has permission to Construct a 40' x 42' Addition

AT 314 Warren Ave 296 D002001

Location of Construction: 314 Warren Ave	Owner Name: Baker Dwight P	Owner Address: 336 Warren Ave	Phone: () 797-3159
Business Name:	Contractor Name: Owner	Contractor Address: Portland	Phone:
Lessee/Buyer's Name	Phone:	Permit Type: Additions - Commercial

Proposed Use: Commercial/SBM Associates	Proposed Project Description: Construct a 40' x 42' Addition
---	--

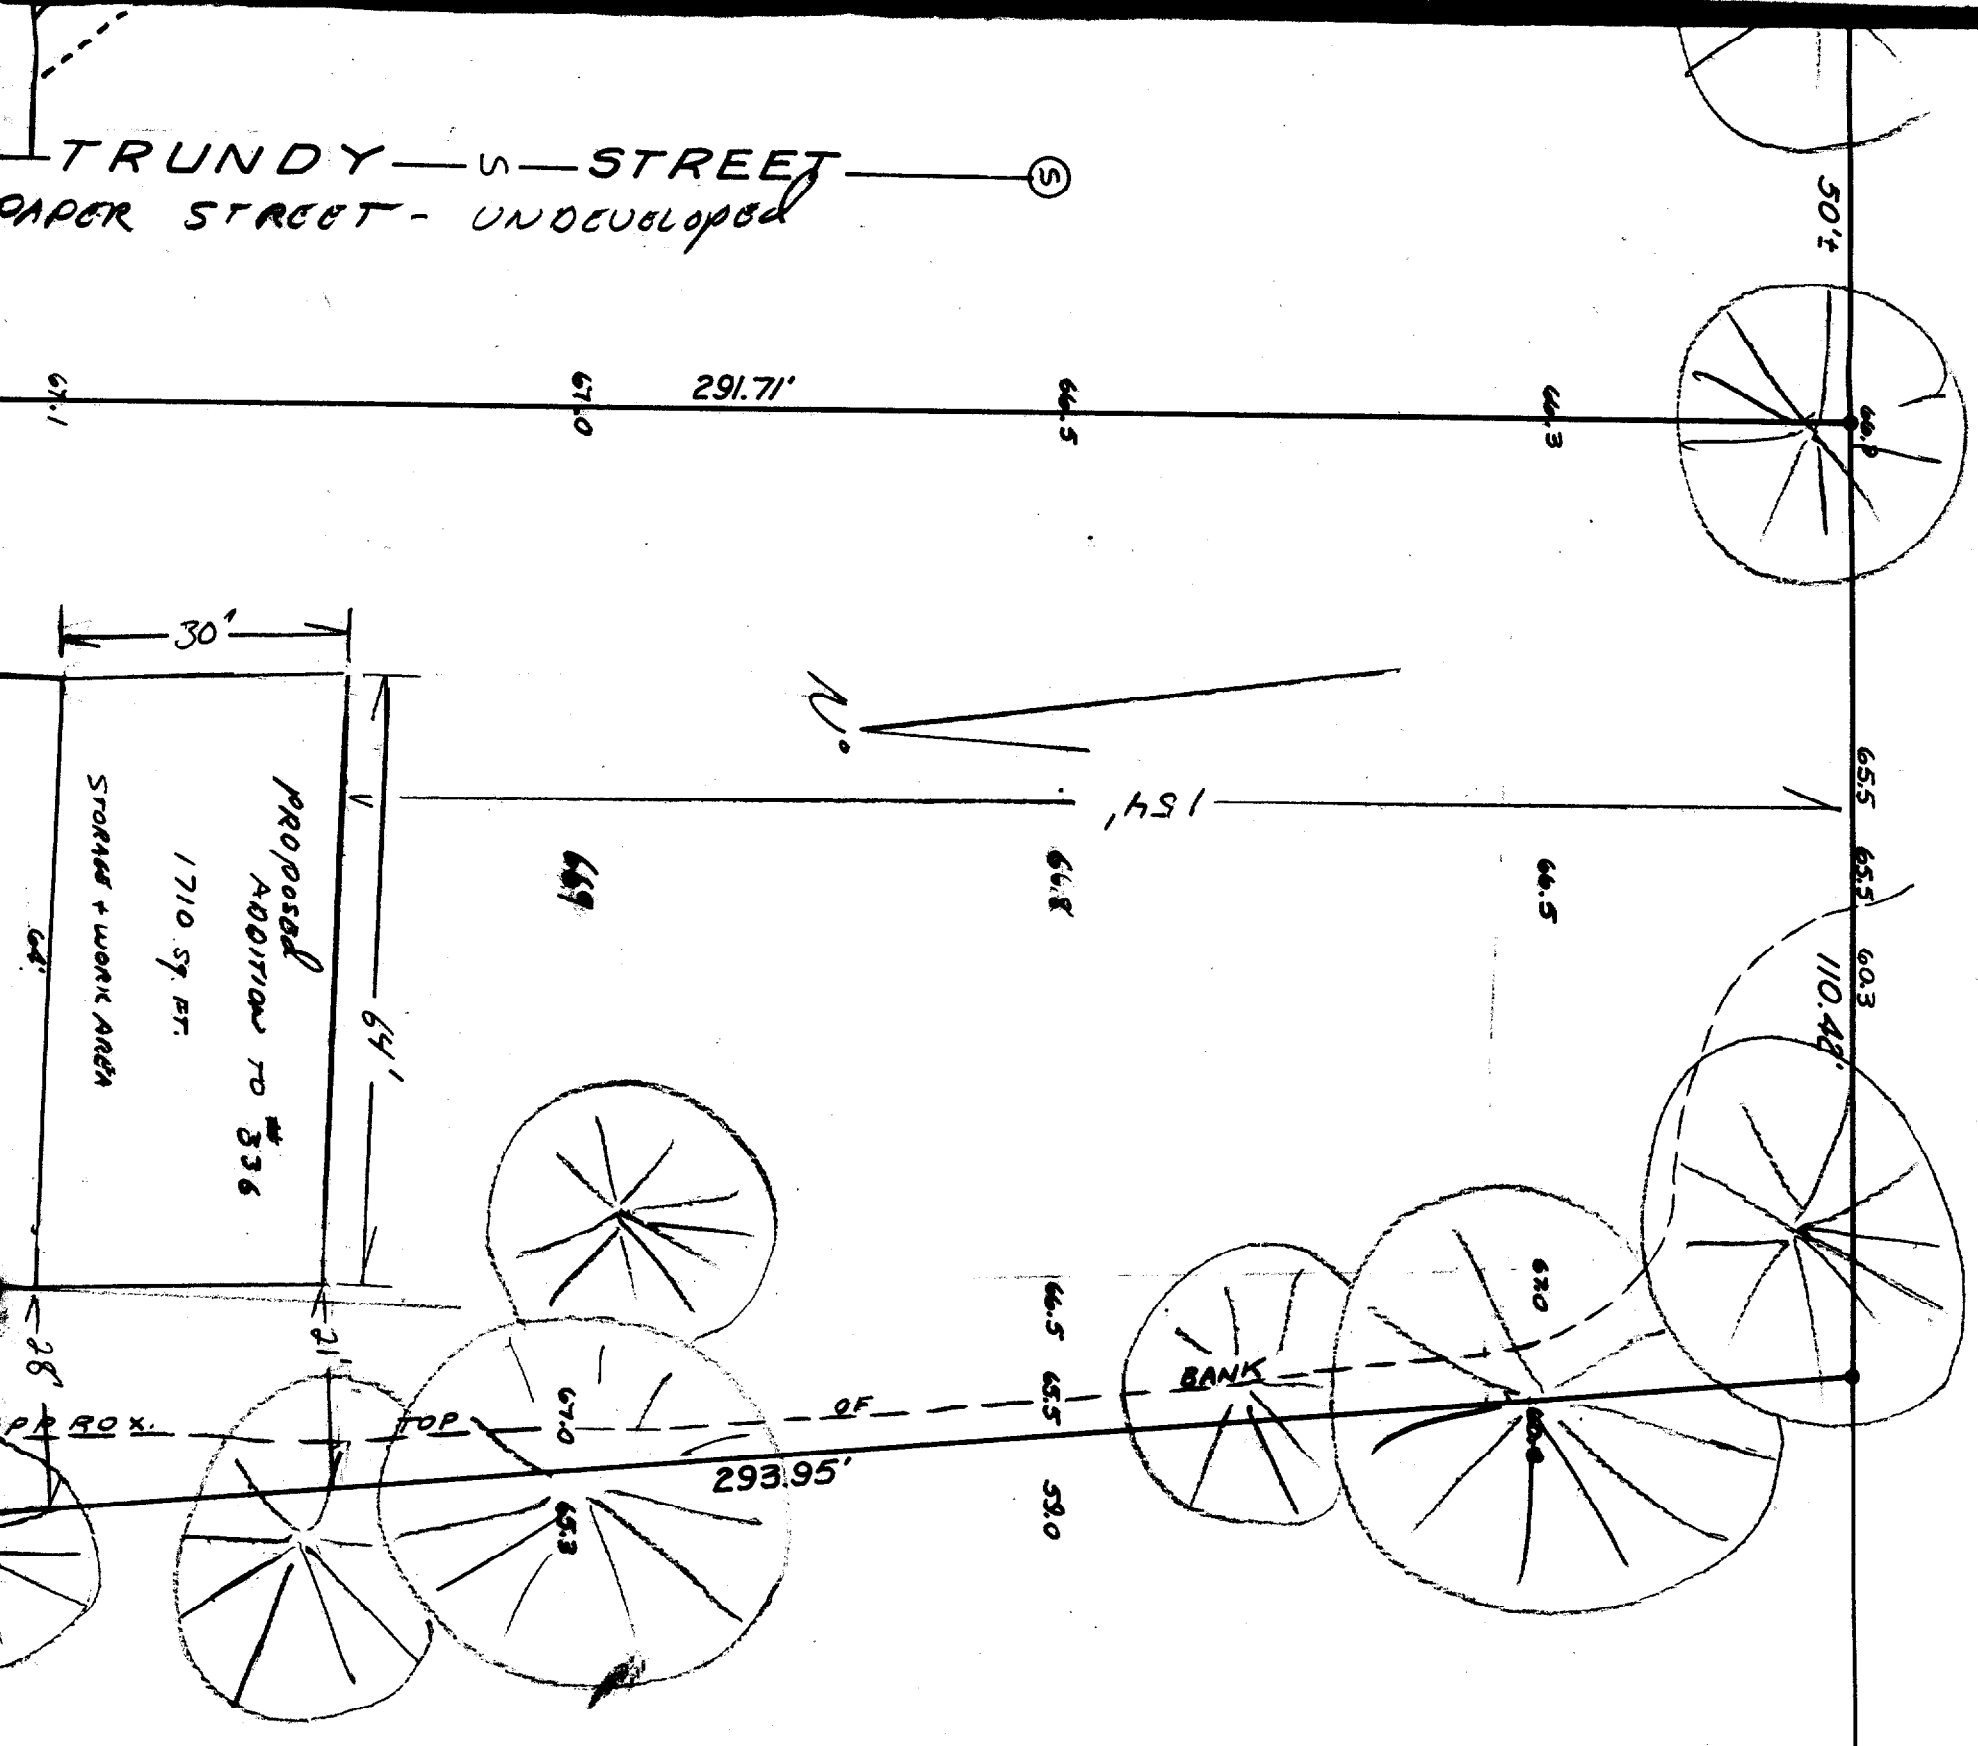
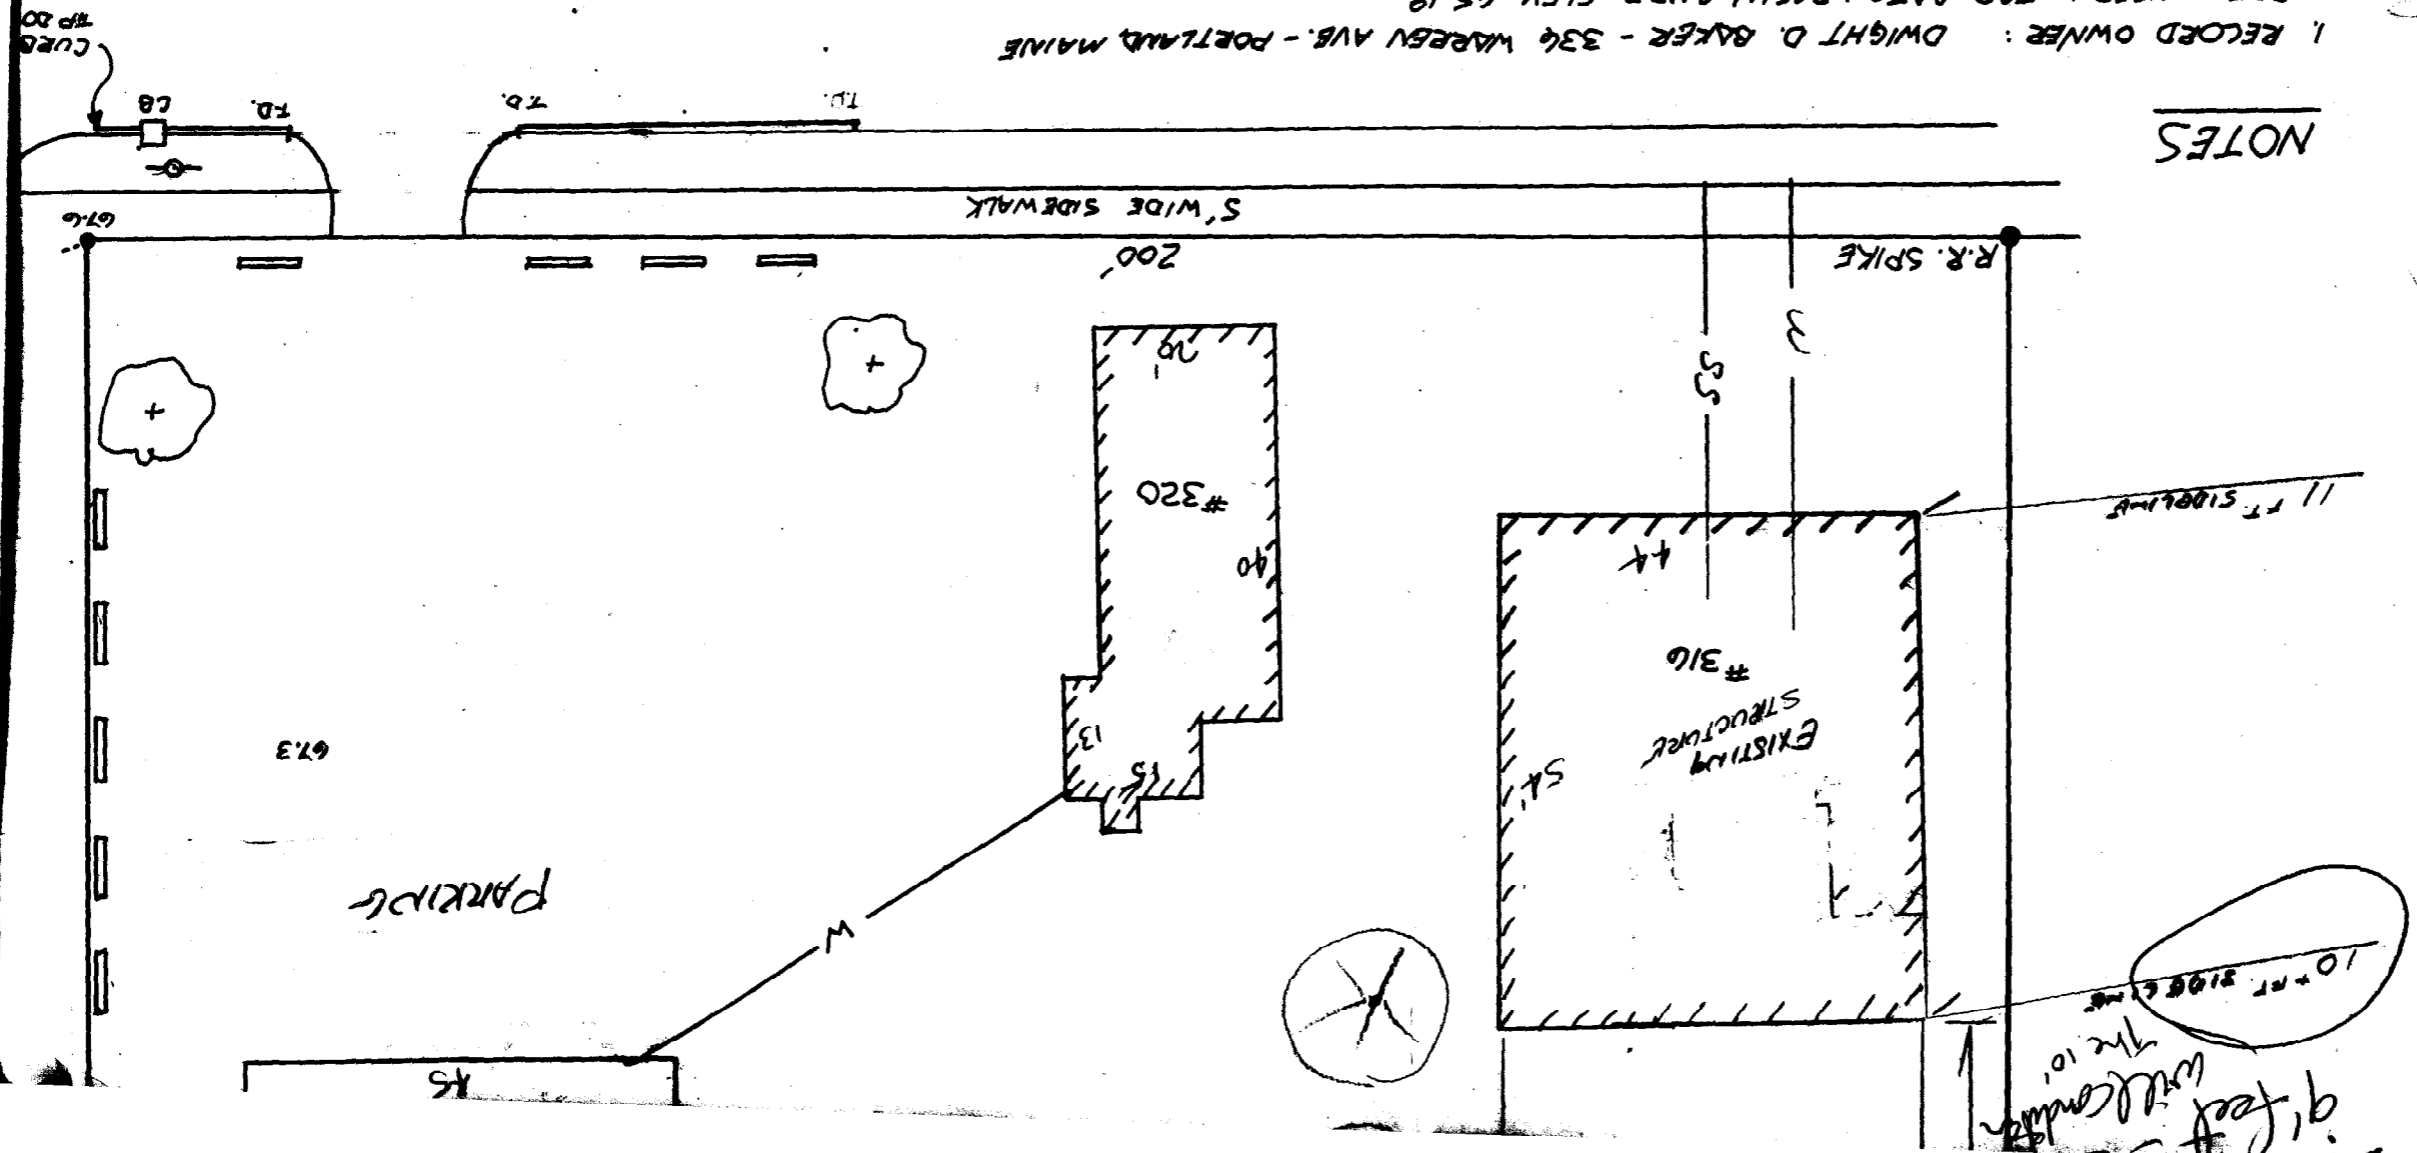
- 1) Because your site plan shows that you have exactly ten (10) feet to the side property line along Fern Street, you will be required to stake the property lines for the Code Enforcement Officer to verify the setbacks PRIOR to pouring of any concrete. It is YOUR responsibility to contact the CEO PRIOR to pouring. A certificated from a surveyor verifying the ten (10) foot setback may be required. Check with your CEO PRIOR to pouring.
- 2) Separate permits shall be required for any new signage.
- 3) This permit is being approved on the basis of plans submitted on 9/10/03. Any deviations shall require a separate approval before starting that work. Please note that the revised approved site plan is the documented and official plan to show setbacks. The hand sketch that was also submitted later is not a legal, approved site plan and would not be considered accurate.

10' req - ~~8' shown~~ 9/10/03 revised site plan states a 10' side setback on the FERN side
